# **Vattenfall Wind Power Ltd**

## **Thanet Extension Offshore Wind Farm**

Annex A to Appendix 7 to Deadline 4 Submission:  
DCO Changes Log

Revision D

Onshore Street Work Plans - Sheet 1 of 2

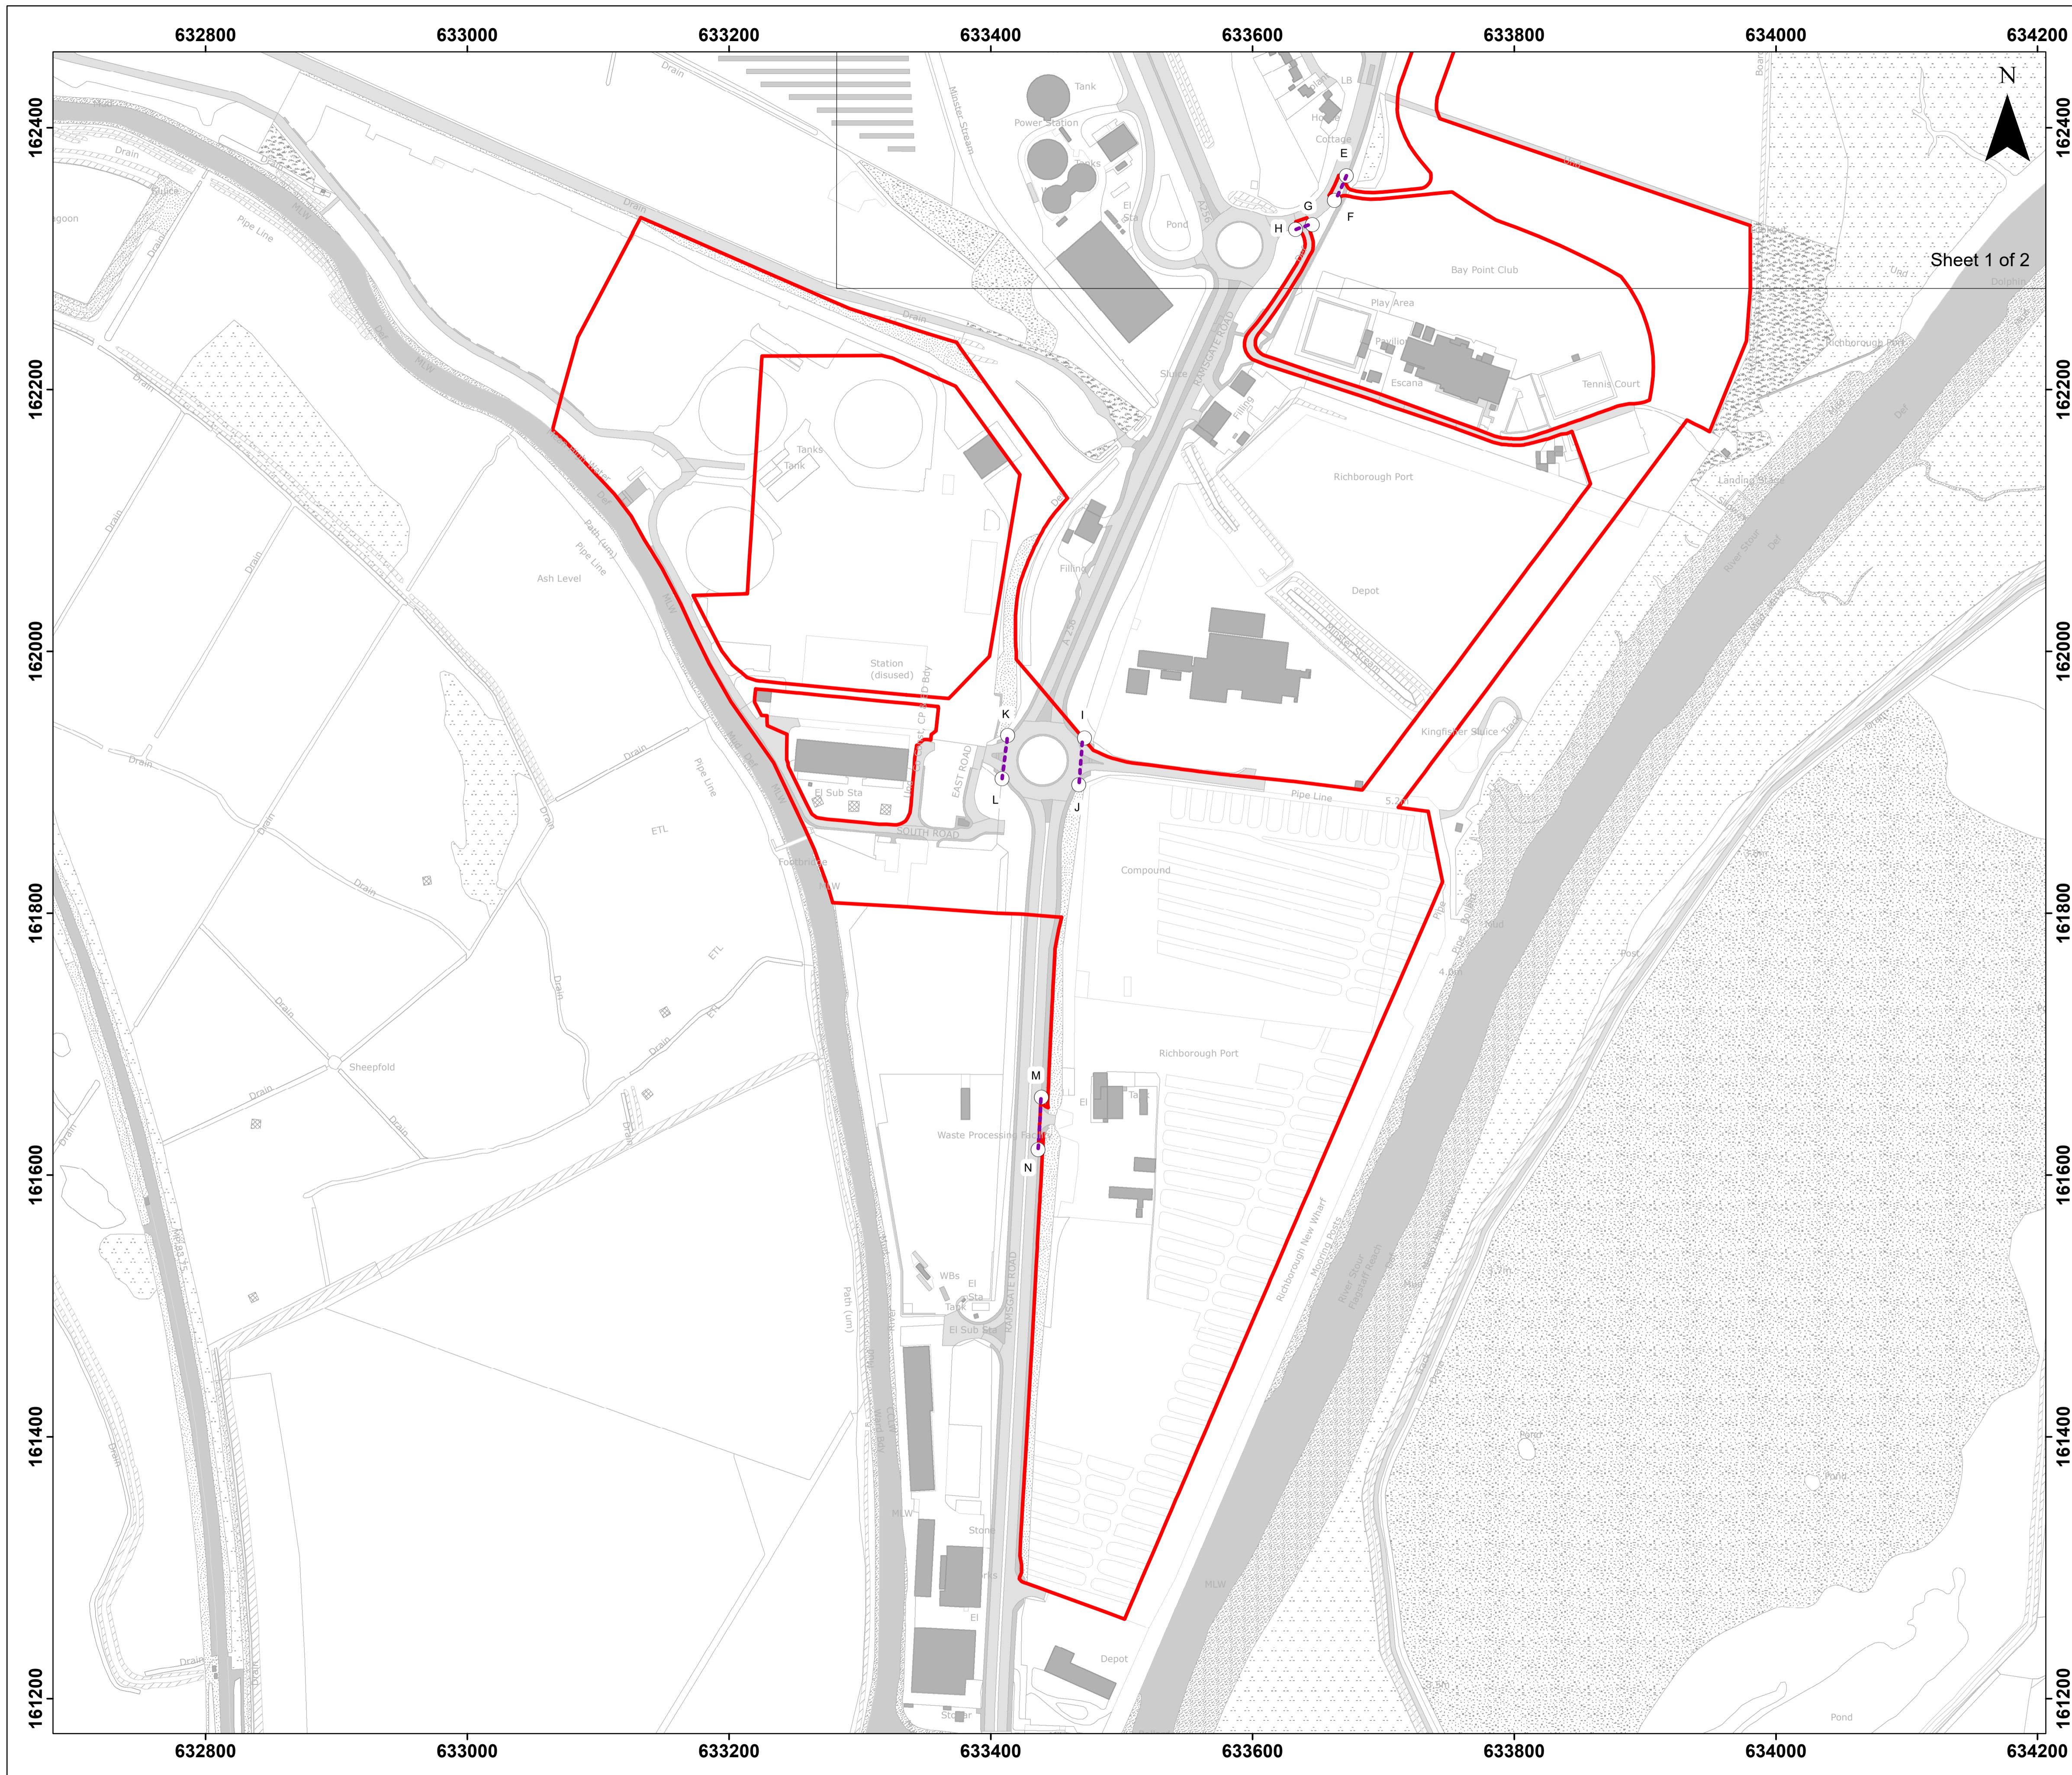
Ref	DCO Ref.	Rationale for change	Change made	DCO Version
1.	Schedule 2	In their Section 51 advice issued to the Applicant, the Planning Inspectorate noted that:  “In relation to the dDCO Schedule 2, the dDCO refers to the works plans. This should be the onshore street works plans.”	The wording has been amended throughout Schedule 2, for example –  <i>SANDWICH ROAD at reference point A-B on the <u>onshore street</u> works plan</i>	2
